REPORT UPDATE

Application No: BR/180/24/PL

REF NO: BR/180/24/PL

PROPOSAL: Change of use from 8 bedroom House in Multiple Occupation (HMO) to 11 bedroom HMO. This application is in CIL zone 4 and is CIL liable.

Drg. No. PG.9011 · 24 · 02 Rev. E

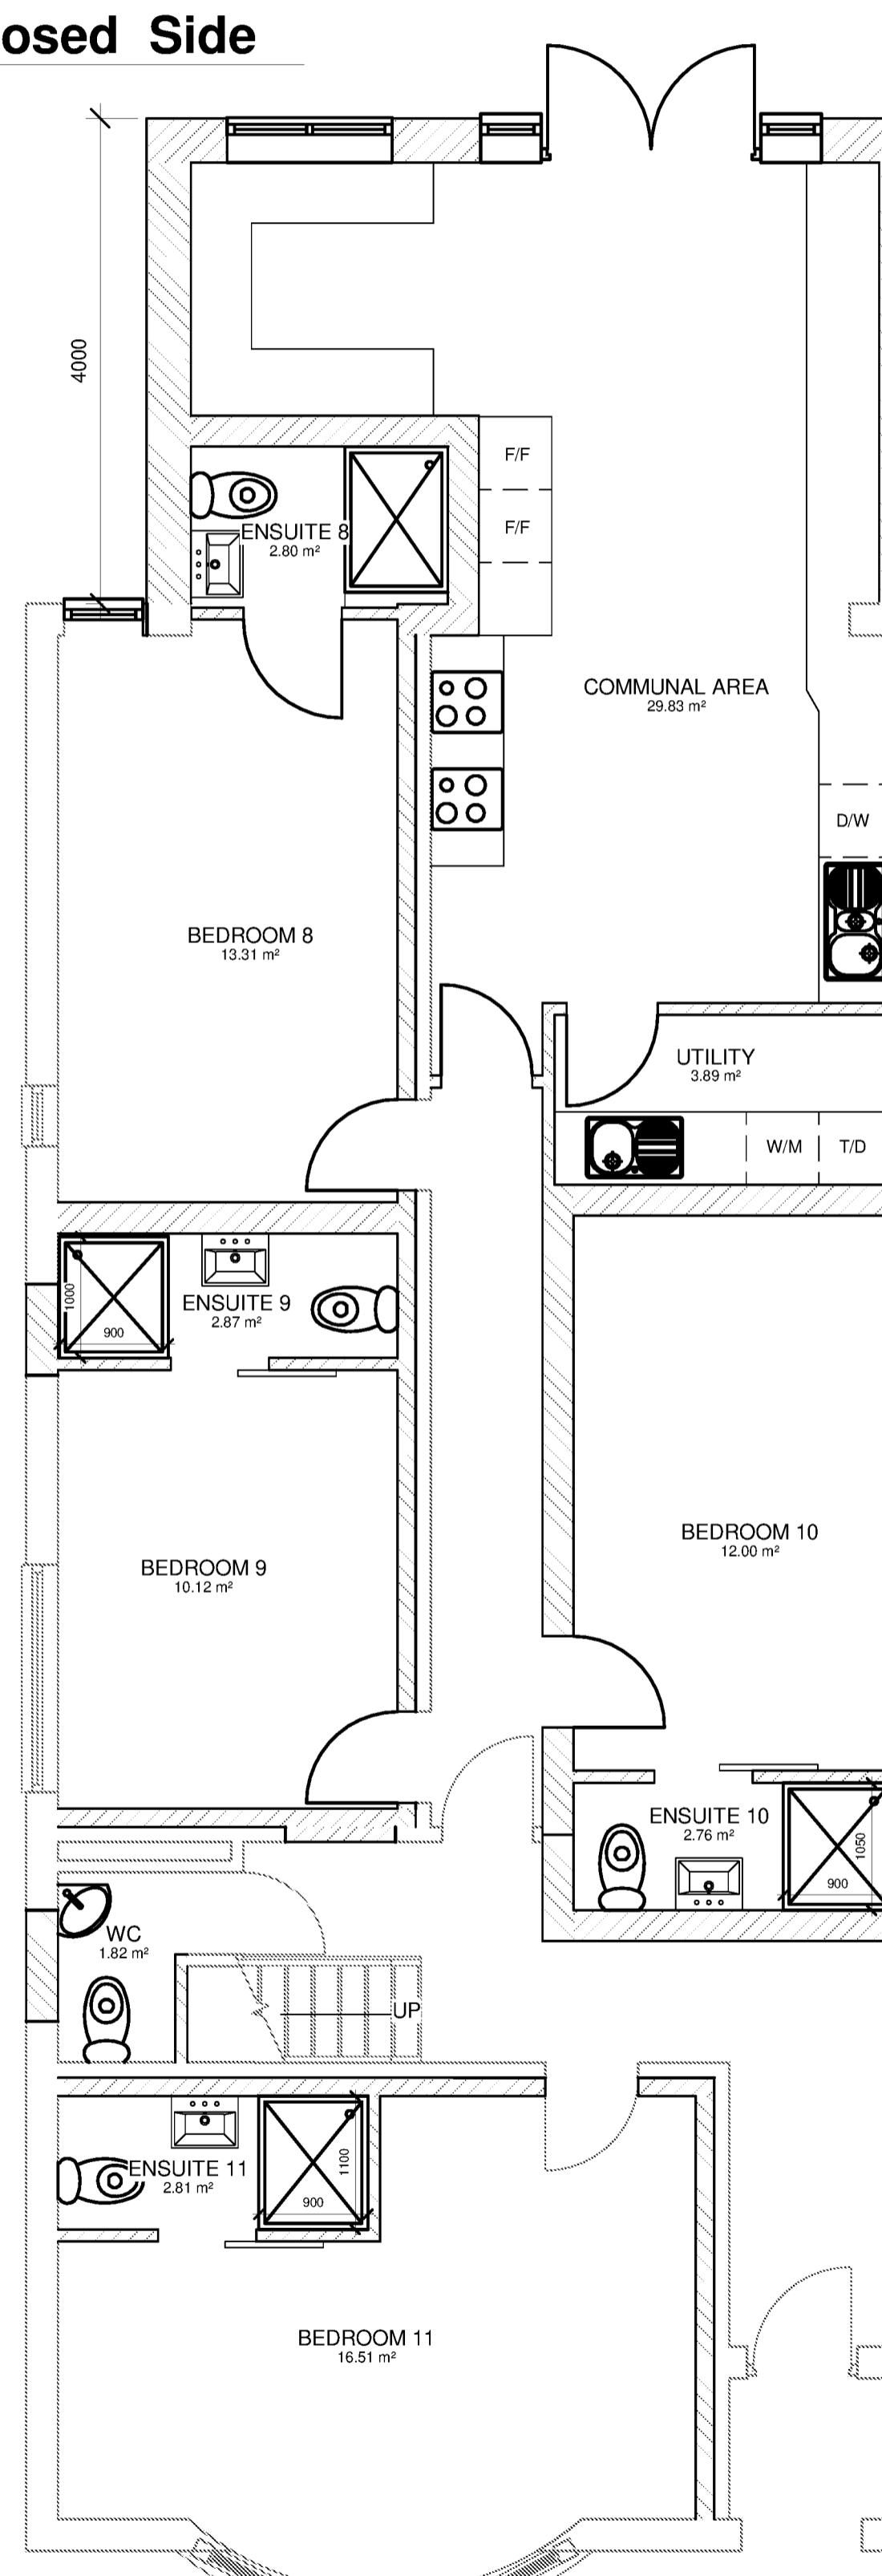
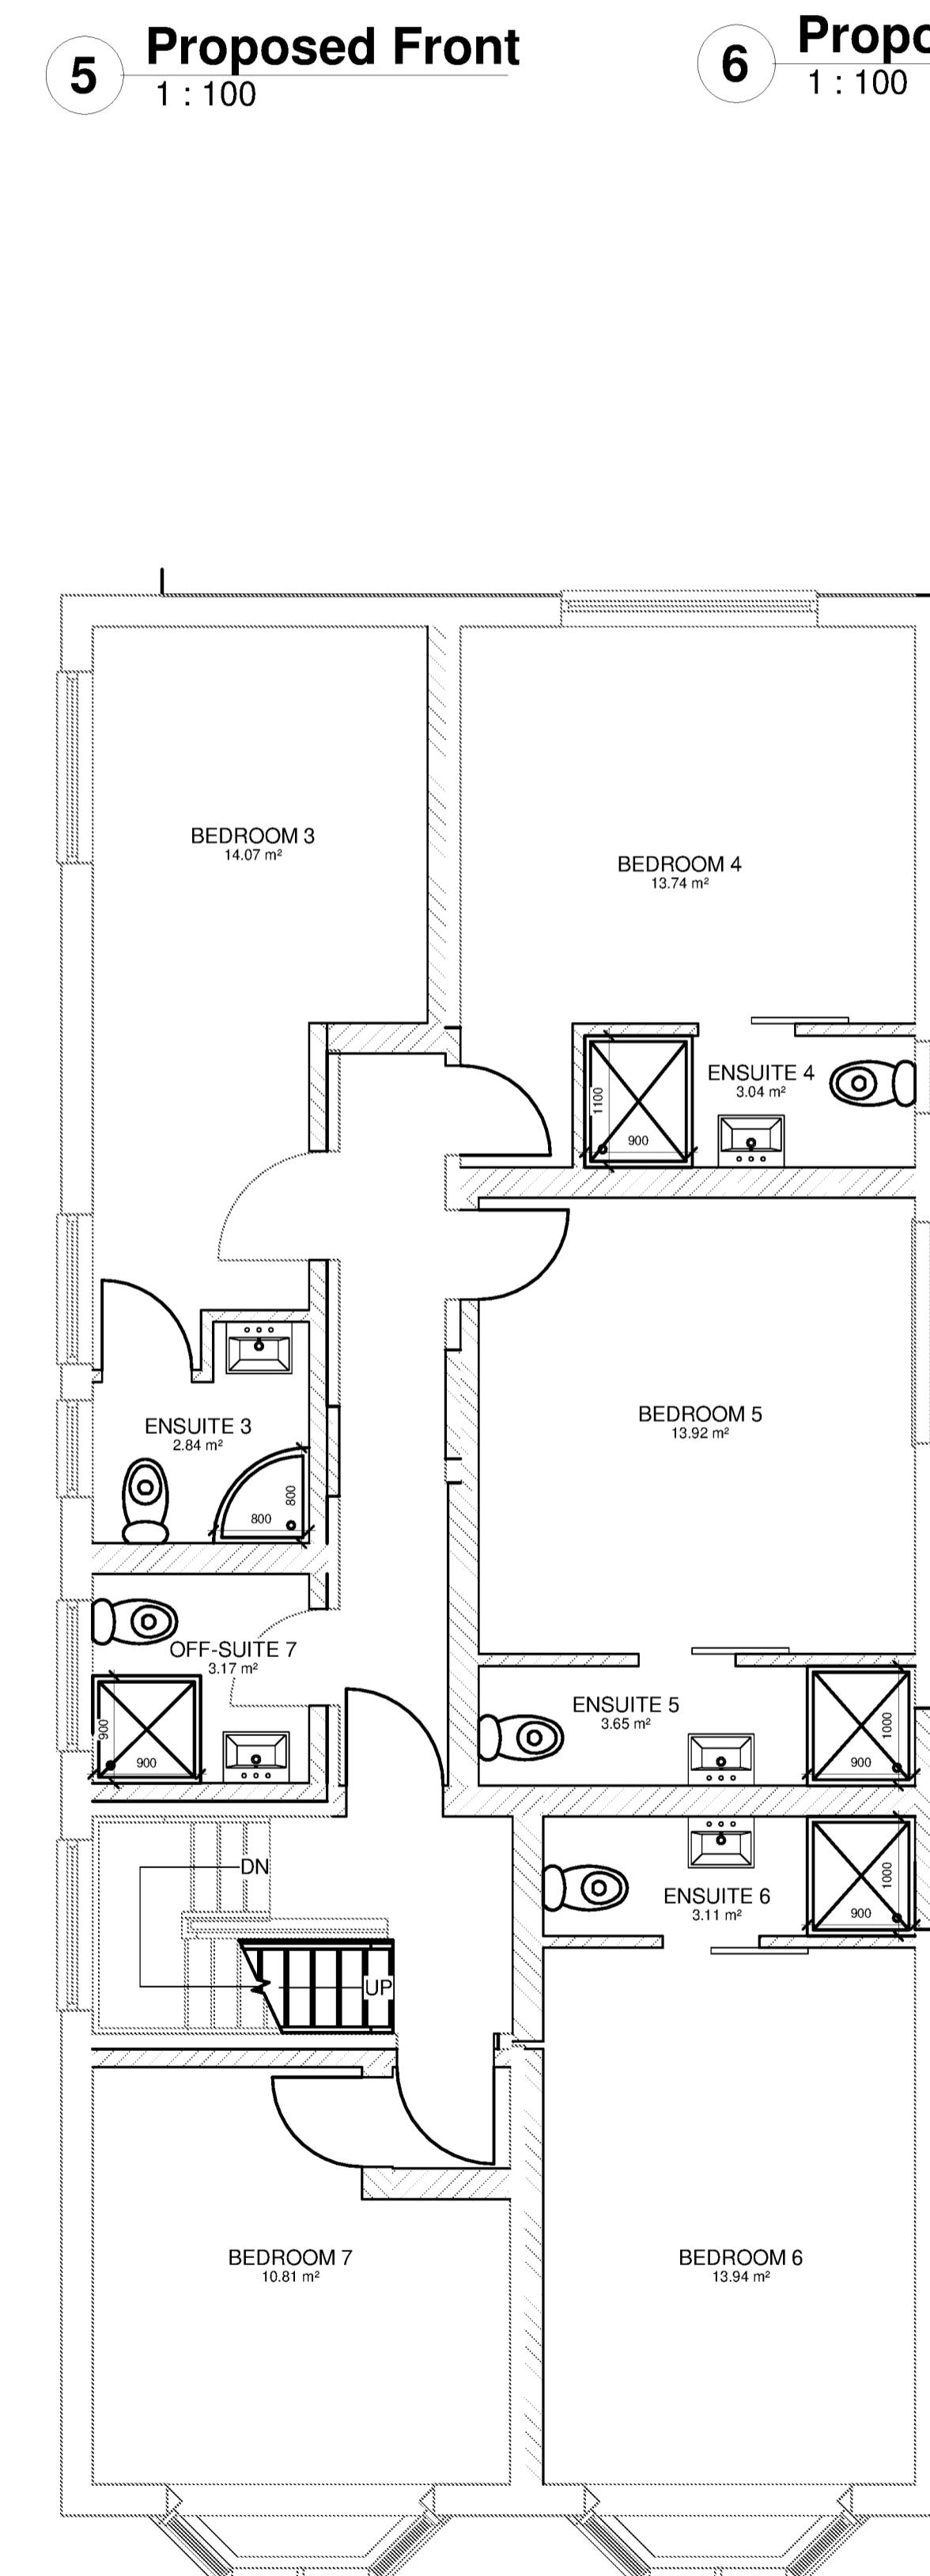
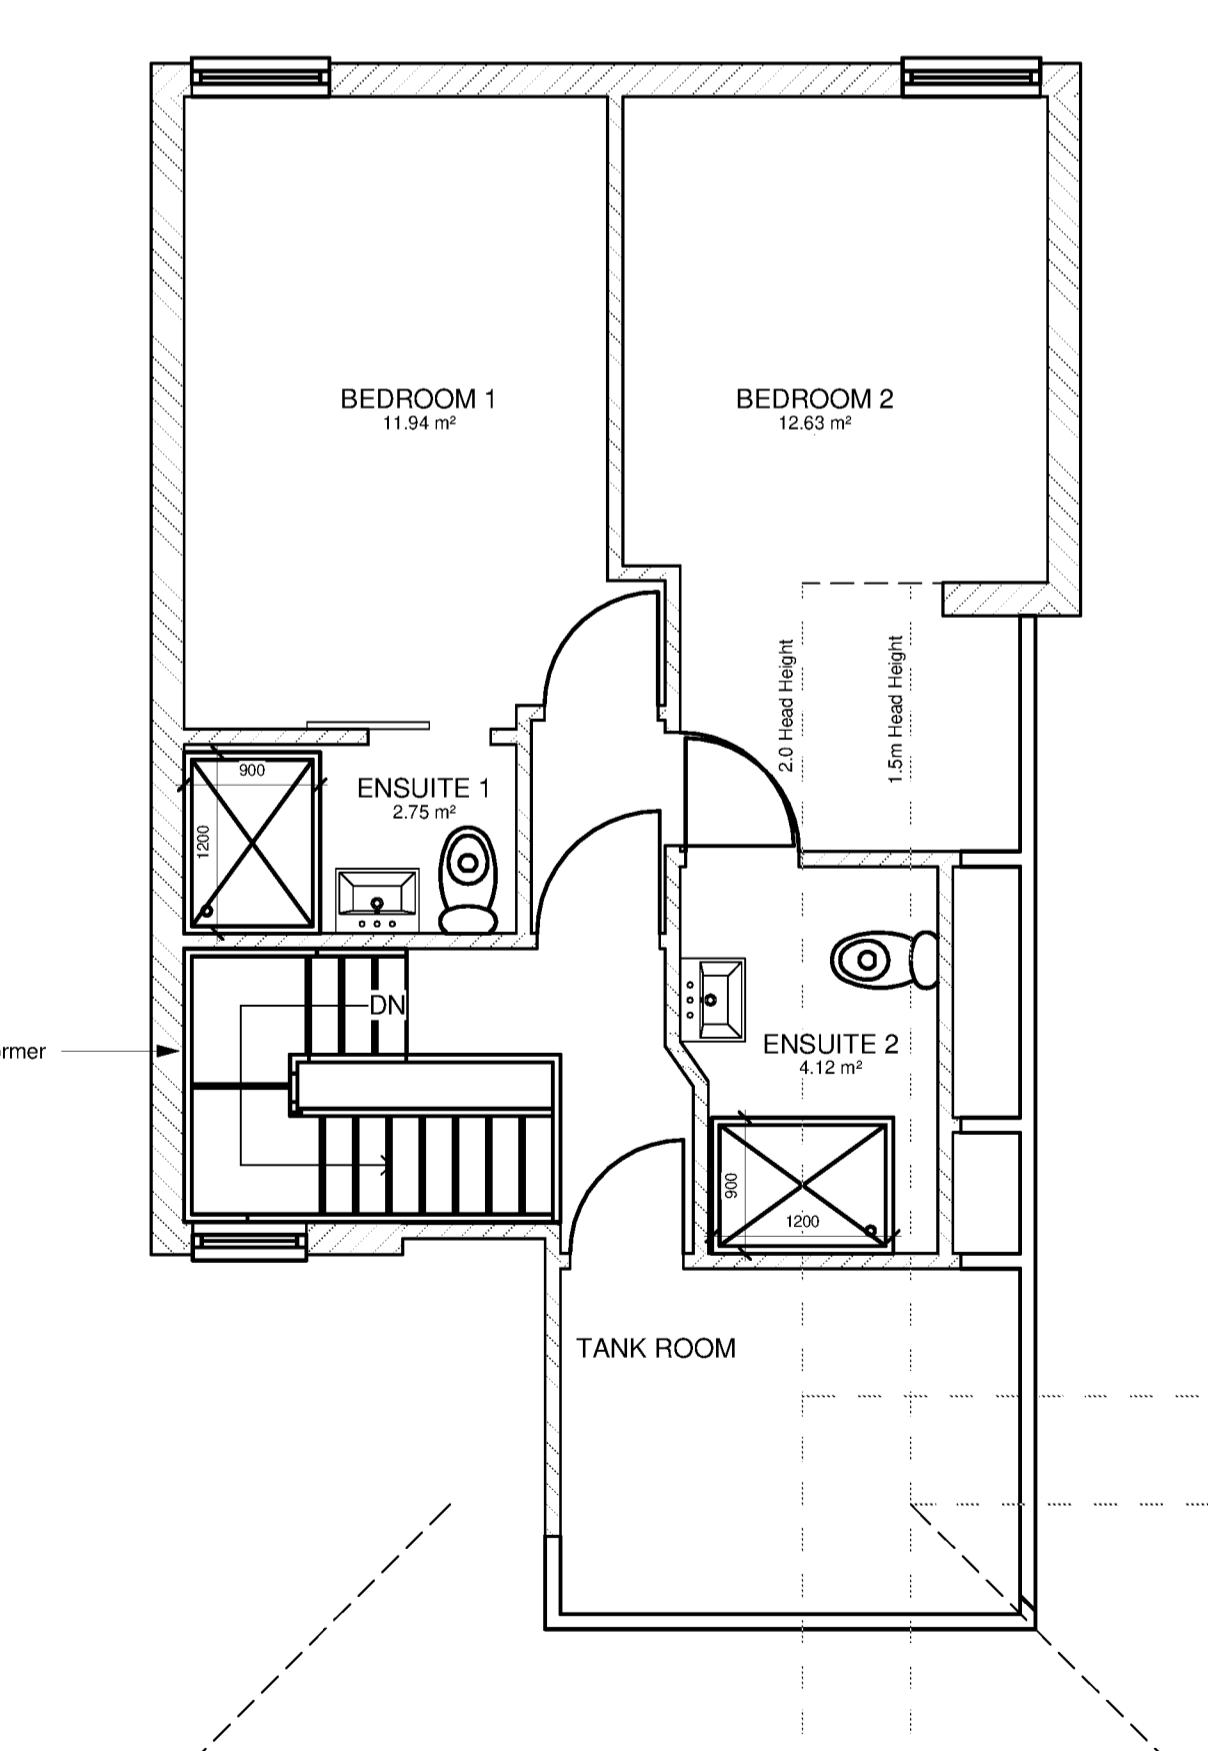
Proposed Plan PG.9022.24.02 has been updated from Revision E to F. This is due to an omission of a door to bedroom 6, which has been added.

There has also been a small change to the proposed plan which has not been mentioned within the report. In order to address concerns raised by ADC Private Sector Housing and Public Health in regard to bathroom sizes, the doors to all en-suites (bar bedroom 2) have been replaced with sliding doors, to increase the usability of the bathroom space. Attention is also drawn to the Proposed Site Plan, which details 1 no. Electric Bike Charger, which has not been mentioned in the report, but increases alternative transport options for occupiers.

Drawing Title
Proposed Site Plan and
Bike Store

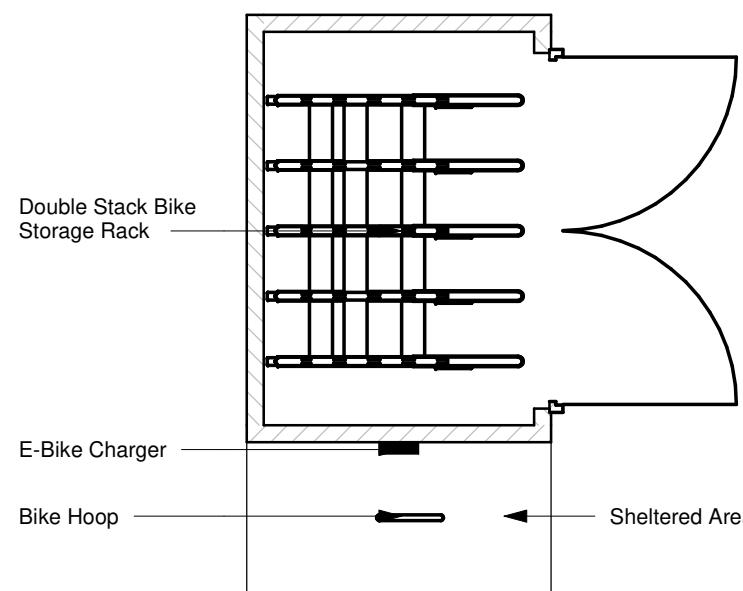
- Would result in overdevelopment of the site through the intensification of use which would result in the inability of the site to accommodate a sufficient provision of communal recycling bins and safe bin storage areas and secure and covered cycle storage facilities for the prospective occupiers, contrary to policies H SP4, T SP1 and WM DM1 of the Arun Local Plan, Design Guide and the NPPF.

The proposal includes nil parking provision, but does include cycle storage. Whilst parking is required as per H SP4 (b), the location of the proposal, and accessibility to transport infrastructure must be weighed against the lack of parking. The site has been in use as an 8 bed HMO for over 10 years, and during this time no on-site parking has been provided. It is located on the outskirts of Bognor Regis town centre, and as such is in a highly accessible location, being less than a 10 minute walk from the railway station, and approximately 3 minutes from the nearest bus stop. There are no on-street parking restrictions on Cavendish Road and neighbouring roads, though this is on the boundary with the Controlled Parking Zone to the east. Given the high accessibility of the area and history of the site operating with no issue as an 8 bed HMO, the lack of car parking is not a disadvantage, with a range of alternative transport options available to local facilities, and further afield. As the proposal provides a sustainable use of a property in close proximity to the town centre and multiple options for parking or public transport, refusal on the basis of the lack of parking is unjustifiable, as sufficient alternative provision is available.

A condition has been applied securing the proposed secure and covered cycle parking spaces in the rear garden, to enable additional transport options for occupiers.
